VENTURE ON VENETUCCI FILING NO. 1

V1_Final Plat Drawings.pdf Markup Summary

Subject: Owner Certification
Page Label: [1] 096302017 Venetucci Plat-1
Author: dsdparsons
Date: 12/16/2024 11:54:25 AM
Status:
Color: ■
Layer:
Space:

Scale 1" = 100'  
Drawn by PTM  
Checked by DRW  
Date 2025-03-13  
Project No. 096302017  
Sheet No. 2 OF 3

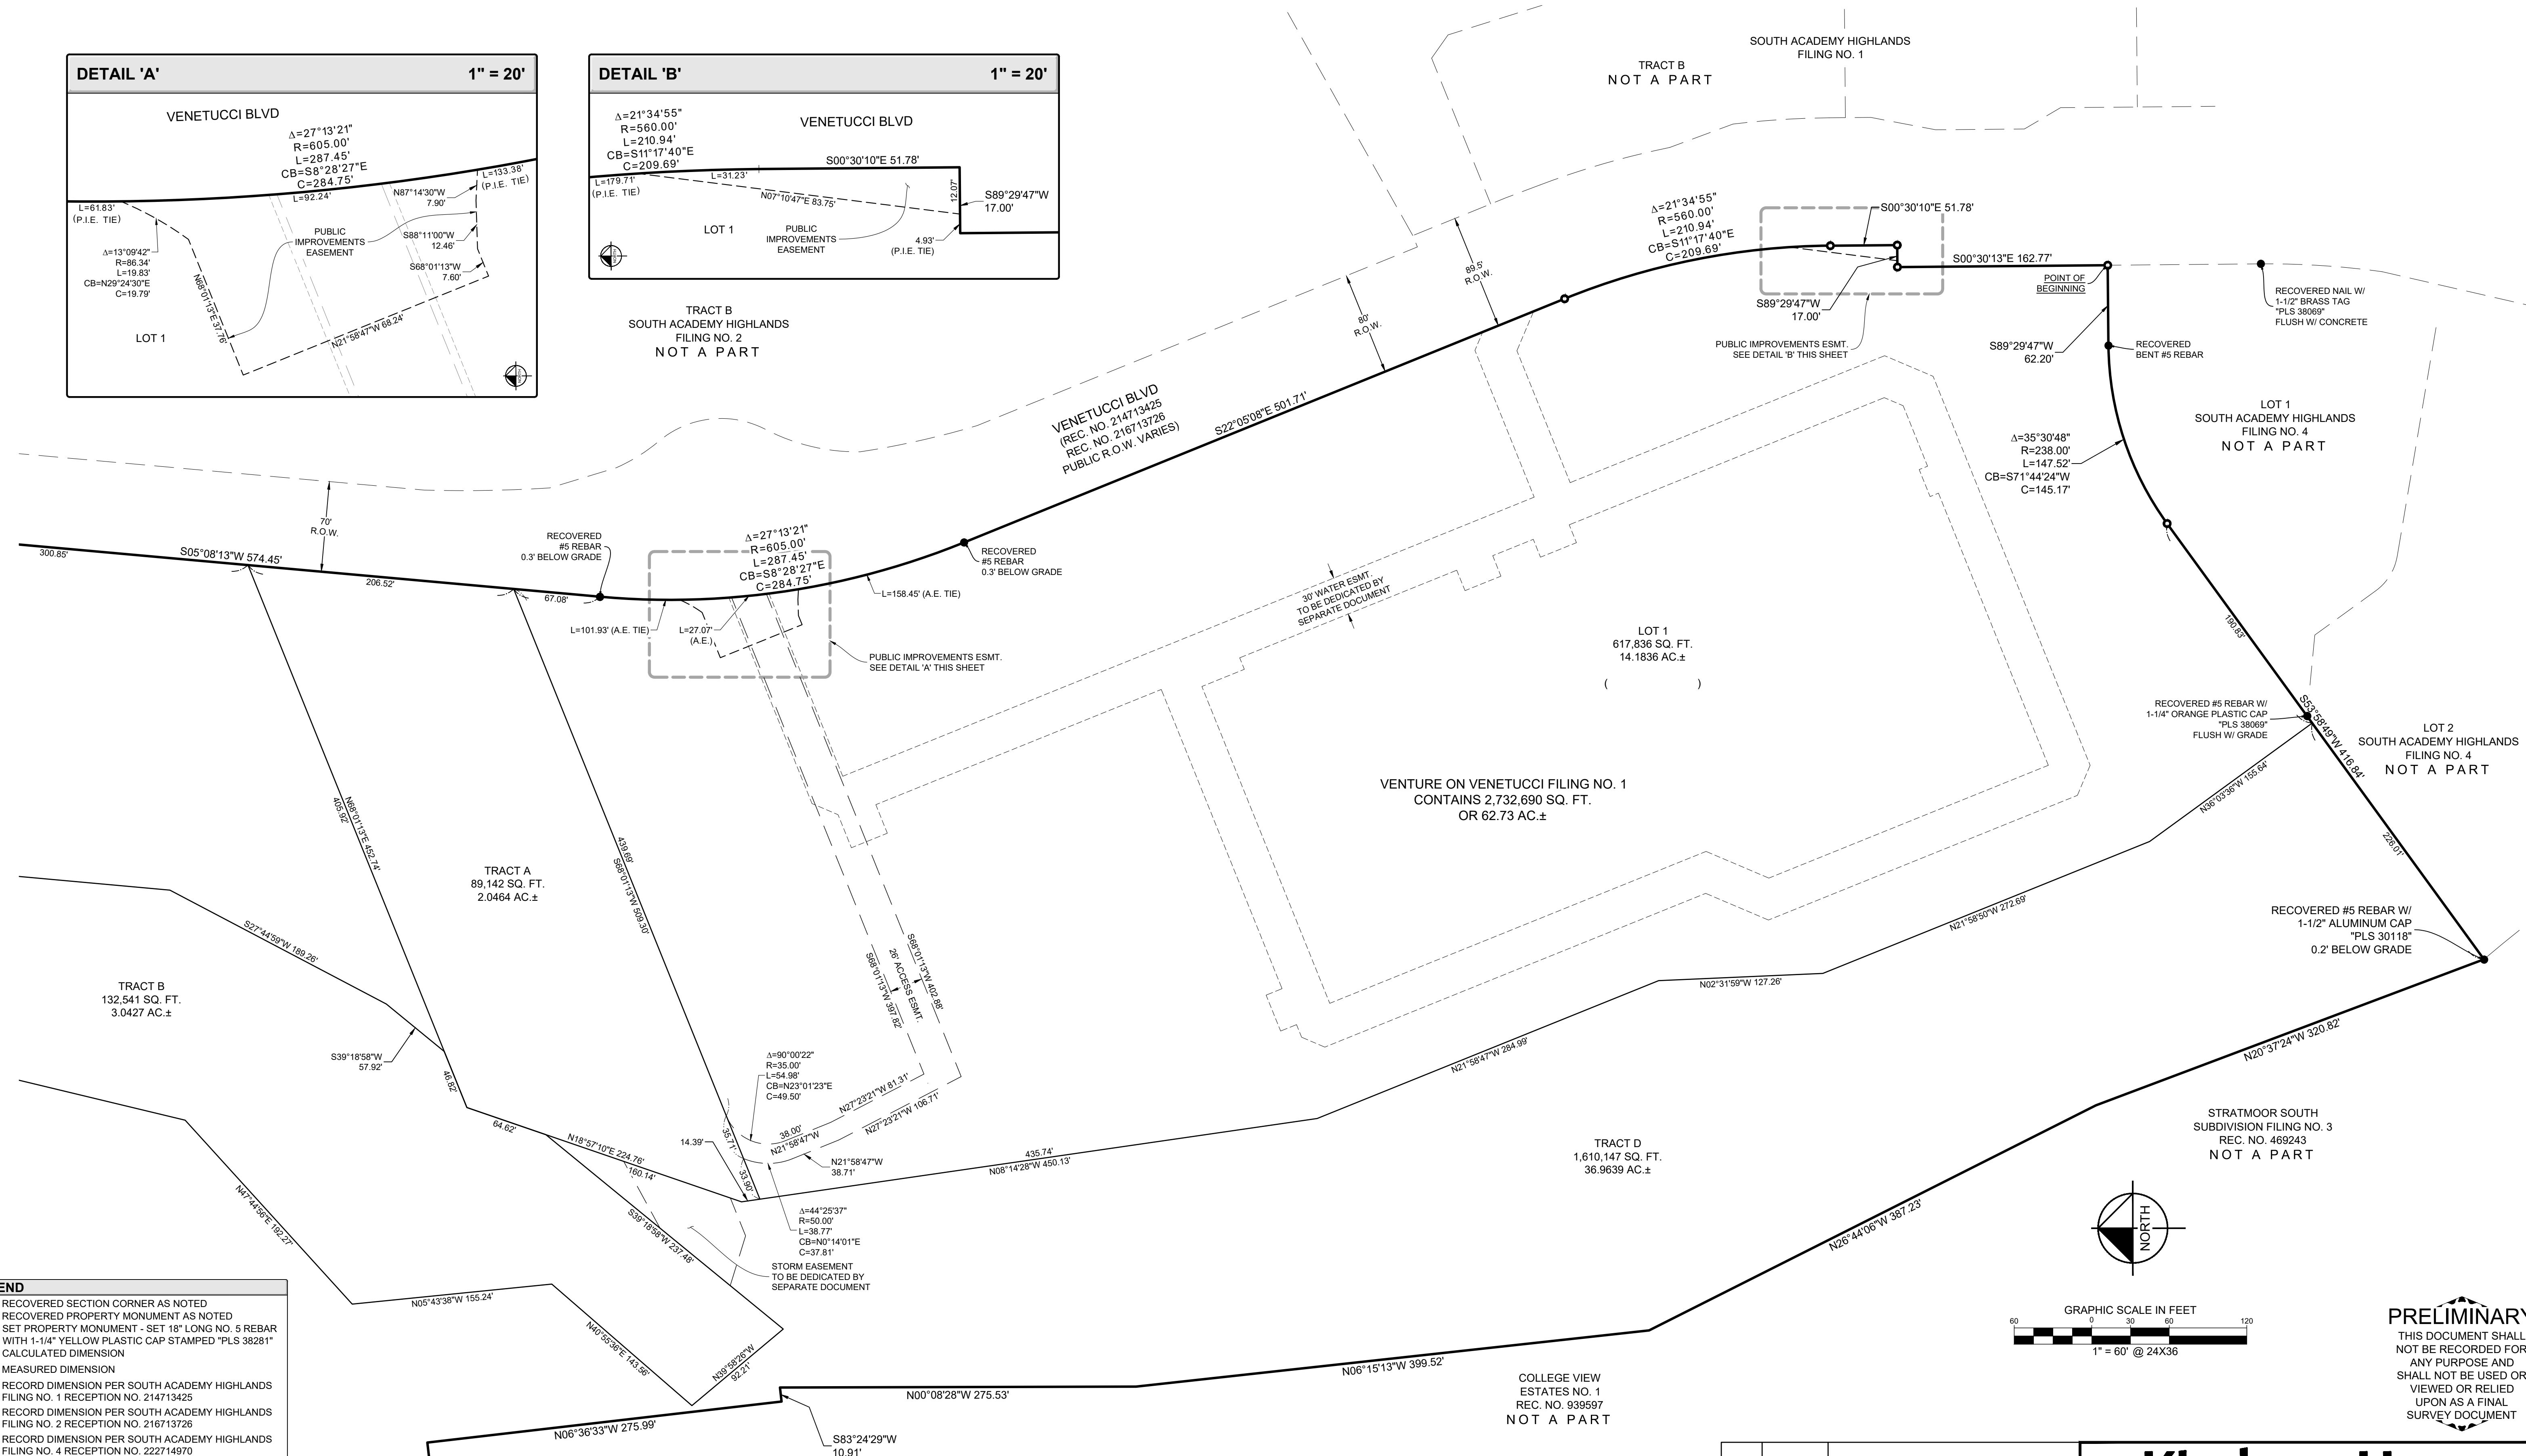
Please place the channel to west that development drains to in a tract; please place the floodplain portion land in a tract. Applicant is doing improvements in these areas. No fees are paid on tracts.; this will allow for simple description in maintenance agreements and make it very clear what is open channel area and what is to be future development when land is sold.

(d)Lots or Portions of Lots within Floodplain.
 (i)Lots Less than 2.5 Acres in Size. Lots less than 2.5 acres in size are required to be located entirely outside of the 100-year floodplain. Lands within the 100-year floodplain shall be established in a tract. A special district, HOA, or other corporate entity shall be designated to maintain the tract unless otherwise provided by this Code.

(D)Planning Required for Remainder Parcels. A remainder parcel shall be at least 35 acres, platted as a tract, identified as a future phase consistent with the preliminary plan, or exempted in accordance with Chapter 7.

are any trail easements proposed?

Please add Public or Private

provide easement and place adj channel in tract.
 NO fees are due on tracts
